Rezoning Transportation Analysis

Petition Number: 2020-111

Reviewer: Kevin Parker, EI

Date	Description
09-10-20	First Review (KP)

SCALE:	AS NOTED	DESIGNED BY: CVS	DRAWN BY: CVS	CHECKED BY: GRR	NO.	REVISIONS	DATE	BY
ZONING SITE PLAN LIGHTBRIDGE ACADEMY DAYCARE								
ORIGINAL ISSUE: 06/22/2020 KHA PROJECT NO. 170171002 SHEET NUMBER 1 OF 1

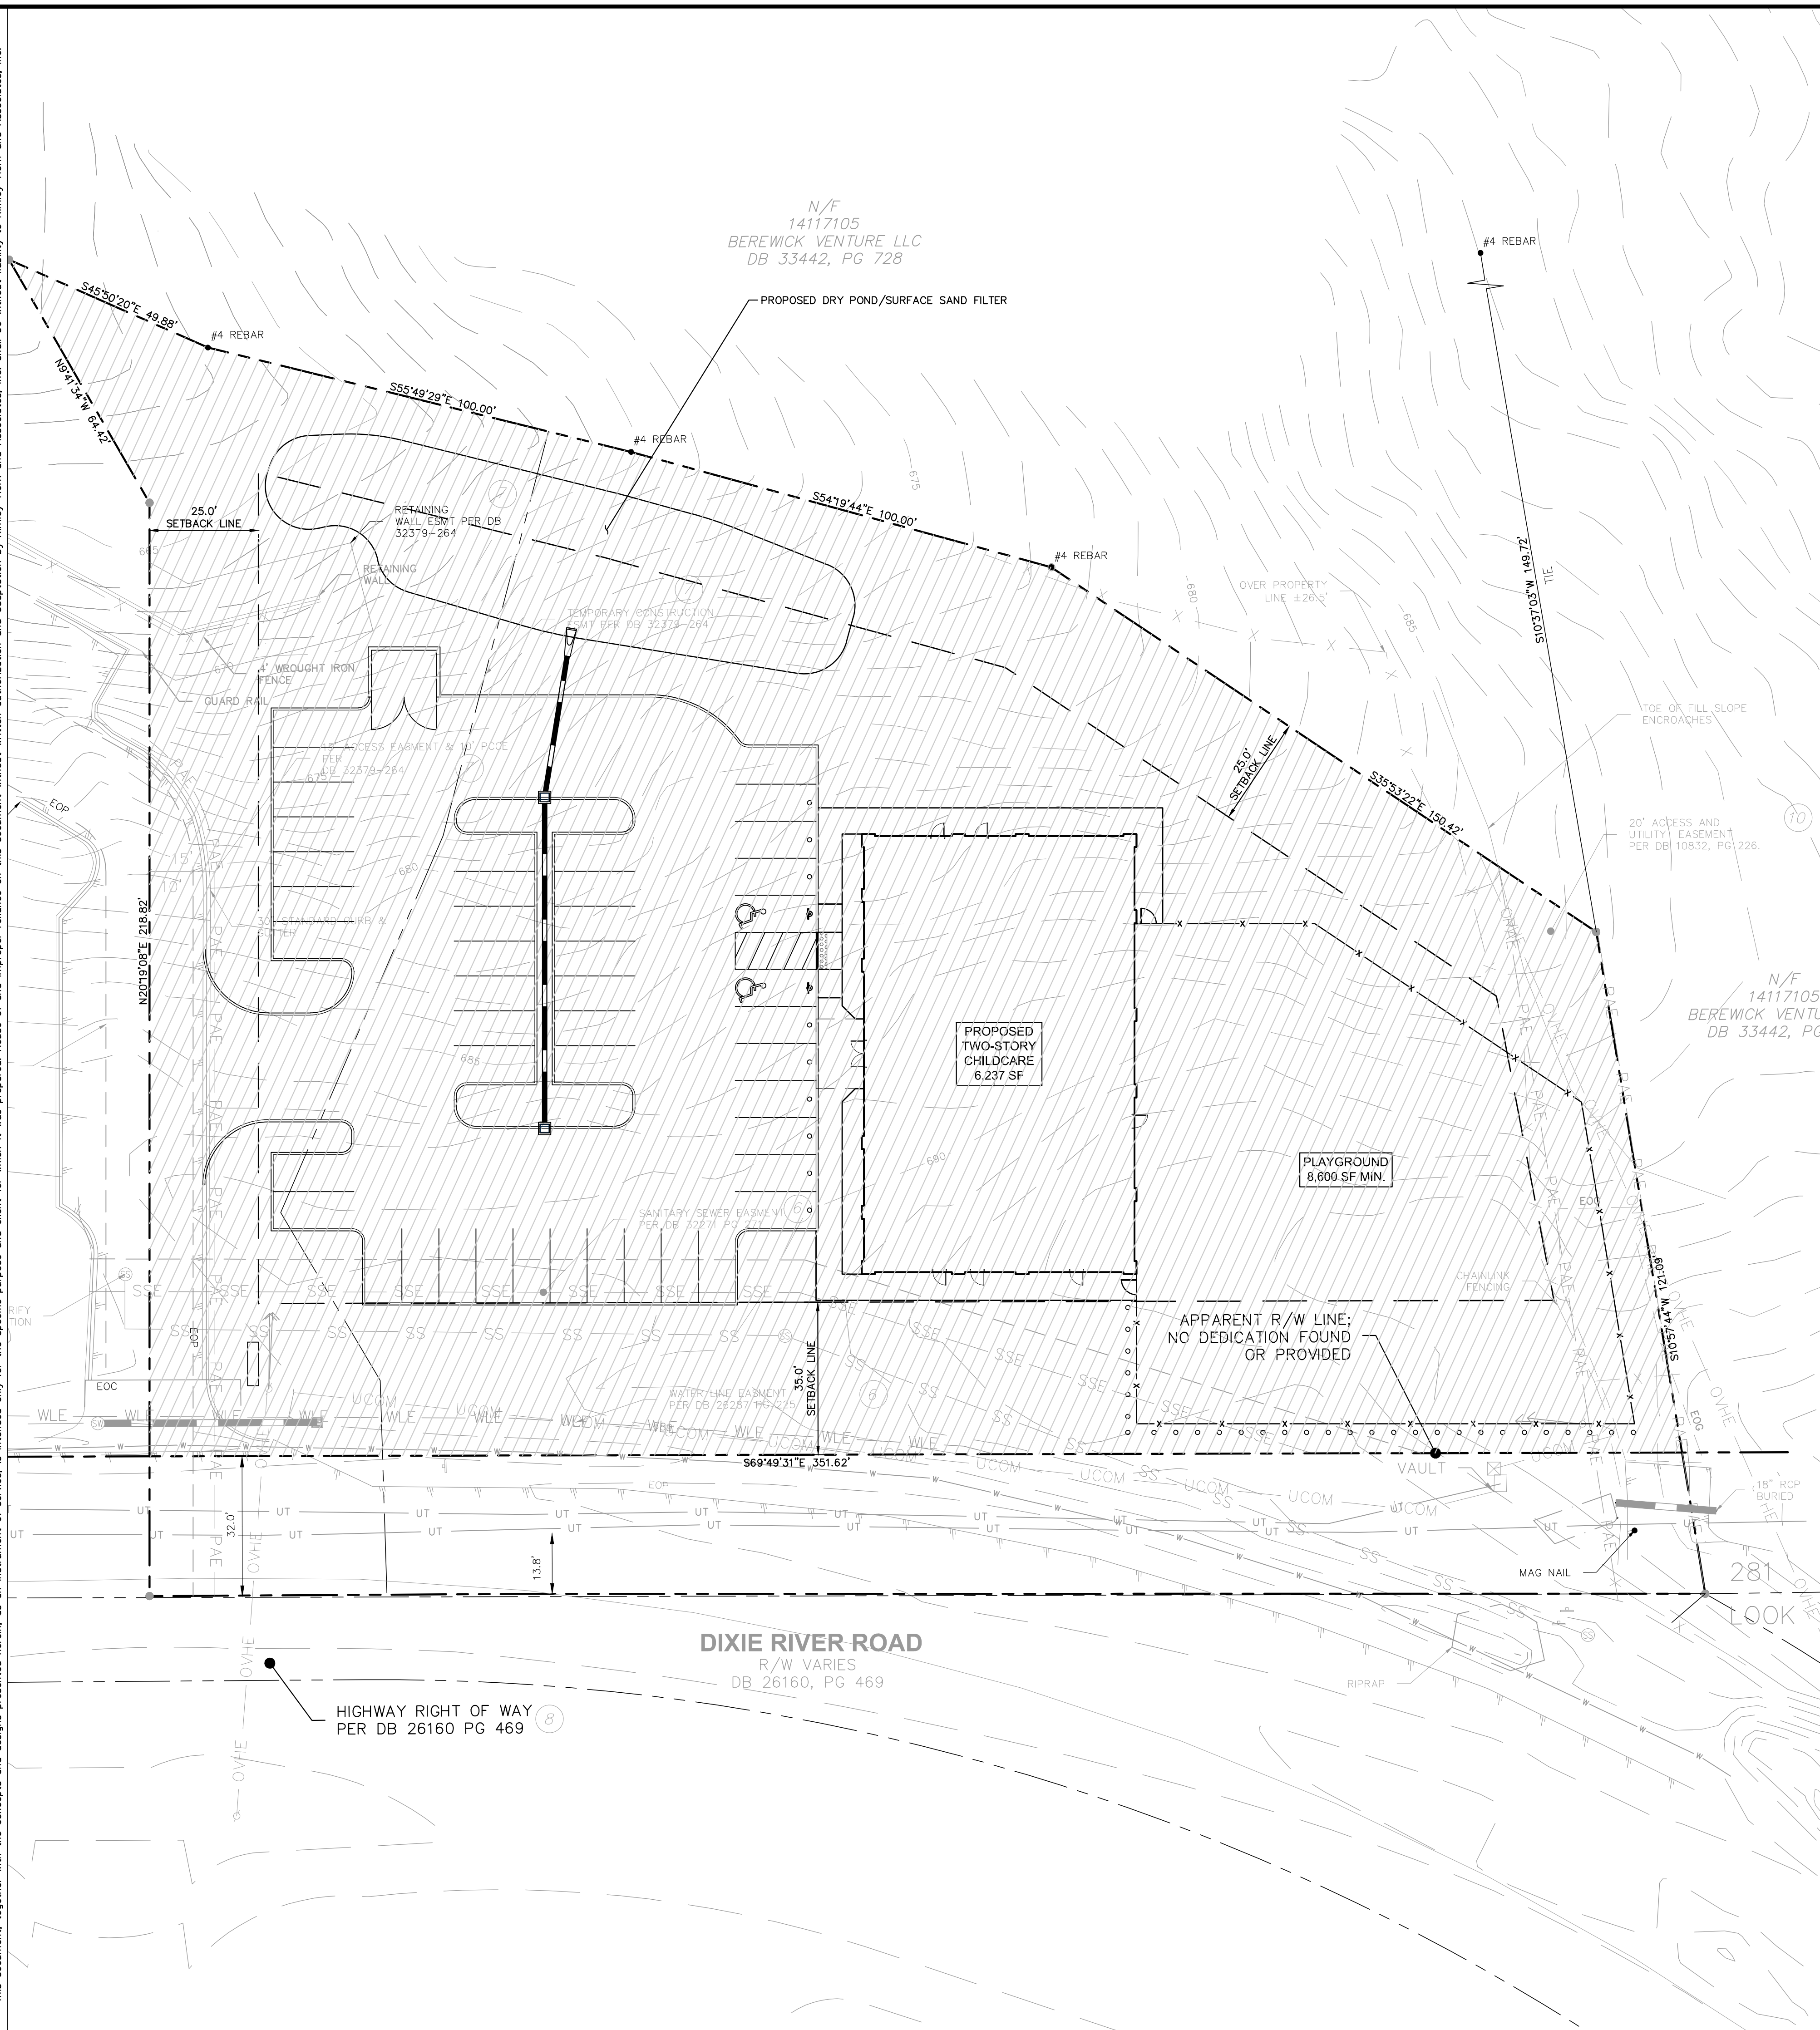
- a. **Dixie River Road:** Update location of curb and gutter 38-feet from center line to back of curb.

Label and dimension curb and gutter from the center line for each road.

- 3. Commit to dedicate 52-feet of right-of-way from the Dixie River Road centerline, labeled and dimensioned from the road centerline, on the site plan and conditional note(s).

- 4. Commit to construct an 8-foot planting strip, and 6-foot sidewalk on Dixie River Road and connect to the sidewalk constructed as a part of the Berewick Senior Apartments development, as required by City Ordinance. This should be shown on the site plan, labeled and dimensioned from the back of curb and gutter and road centerline, as well as noted in the conditional notes.

- 5. The petitioner should revise the site plan and conditional note(s) commit to construction of a 5-foot bike lane with a 3-foot buffer along Dixie River Road, labeled and dimensioned from the road centerline.

- 6. Commit to the removal of the existing obsolete driveway(s) in and near the southeast corner of the property.

7. Site plan needs to show the vehicular movement for daycare pick-up and drop-off to clarify how this process will occur.
8. For street and pedestrian lighting recommendation, coordinate with Anthony Mendez, CDOT. Please visit the following link:
<https://charlottenc.gov/Transportation/Programs/Pages/StreetLighting.aspx>

9. Add a note specifying dedication and fee simple conveyance of all rights of way to NCDOT before the site's first building certificate of occupancy is issued. CDOT requests right-of-way set at 2' behind back of sidewalk, where feasible.

10. Add a note specifying a recorded cross access easement with the shared access drive for the Berewick Senior Apartments.
11. Add a note specifying all transportation improvements will be approved and constructed before the site's first building certificate of occupancy is issued. The petitioner may phase transportation improvements if said improvements and phasing are explicitly described in site plan notes.
